**United Utilities Water Limited
Developer Services & Planning**
Warrington North WWTW
Gatewath Industrial Estate
Barnard Street off Old Liverpool Road
Sankey Bridges
Warrington
WA5 1DS

Your ref: 3/2018/0455
Our ref: DC/18/2421
Date: 06-JUN-18

Location: 39 Clitheroe Road, Whalley, BB7 9AD.

Proposal: Reserved matters including appearance, landscaping, layout and scale for one dwelling.

PROPOSED SITE PLAN

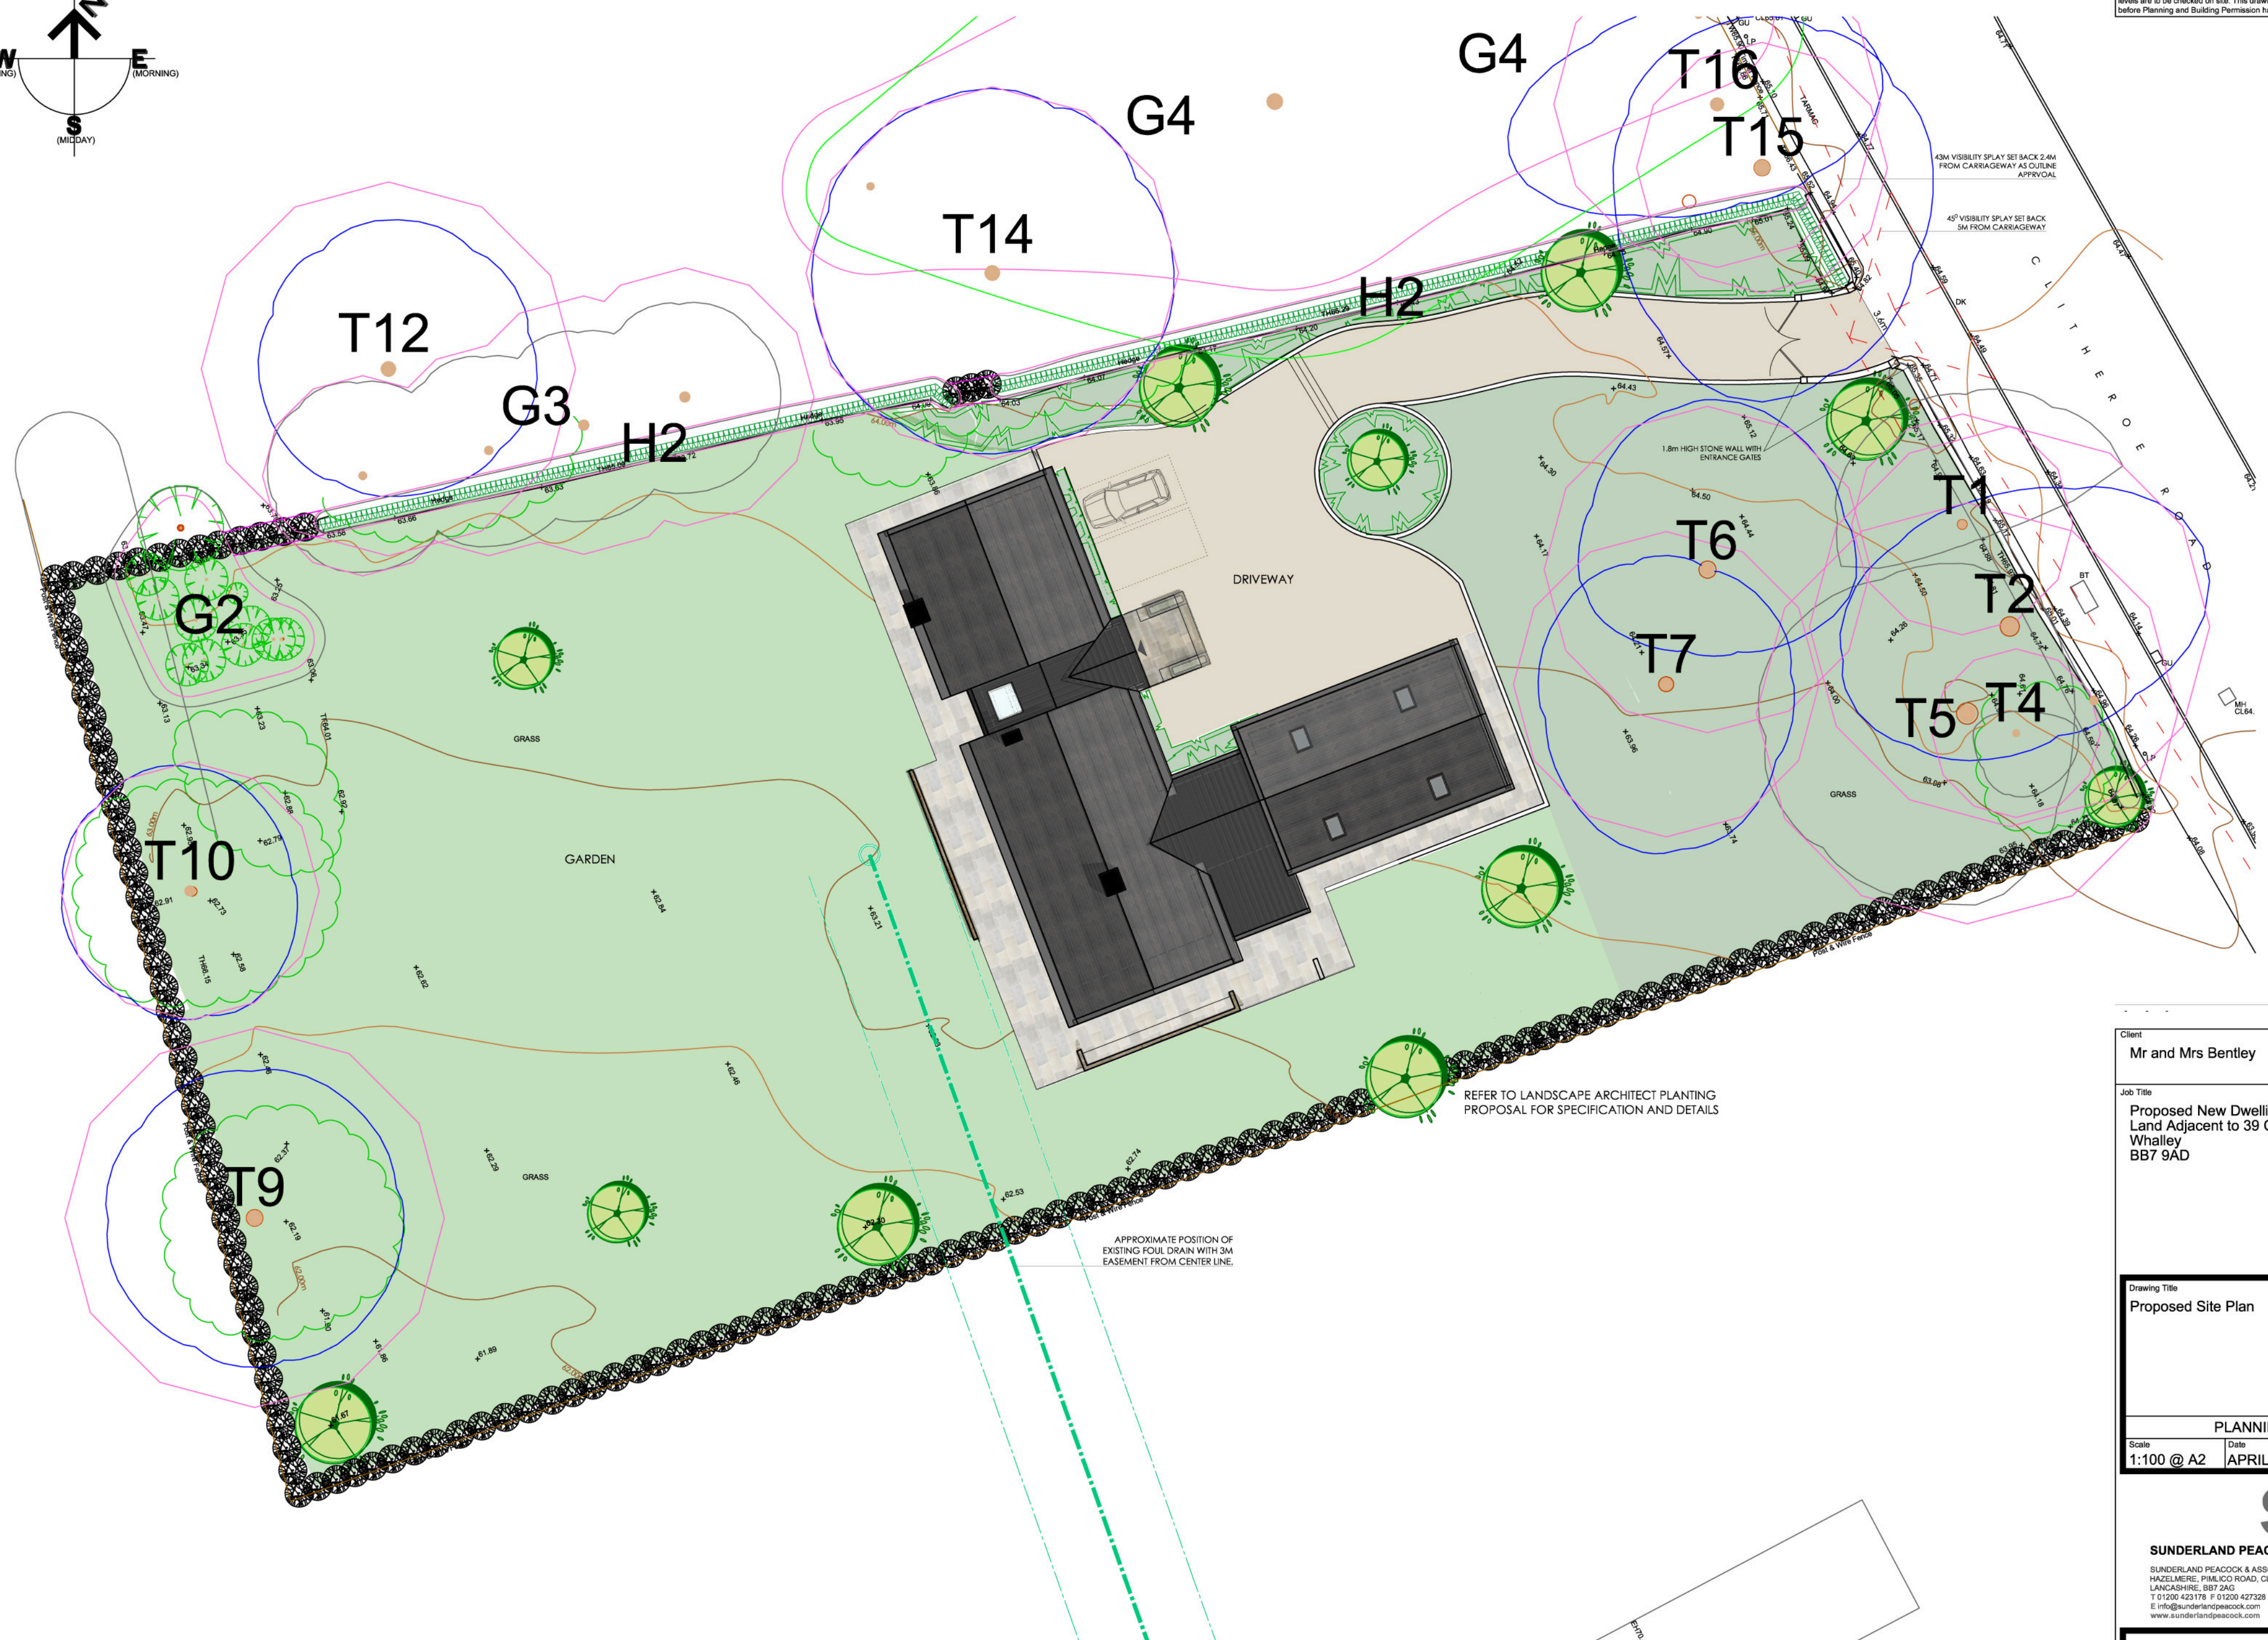
A public sewer crosses this site and we may not permit building over it. We will require an access strip width of six metres, three metres either side of the centre line of the sewer which is in accordance with the minimum distances specified in the current issue of "Sewers for Adoption", for maintenance or replacement. Therefore a modification of the site layout, or a diversion of the affected public sewer at the applicant's expense, may be necessary. To establish if a sewer diversion is feasible, the applicant must discuss this at an early stage with our Developer Engineer at wastewaterdeveloperservices@uuplc.co.uk as a lengthy lead in period may be required if a sewer diversion proves to be acceptable.

Deep rooted shrubs and trees should not be planted in the vicinity of the public sewer and overflow systems.
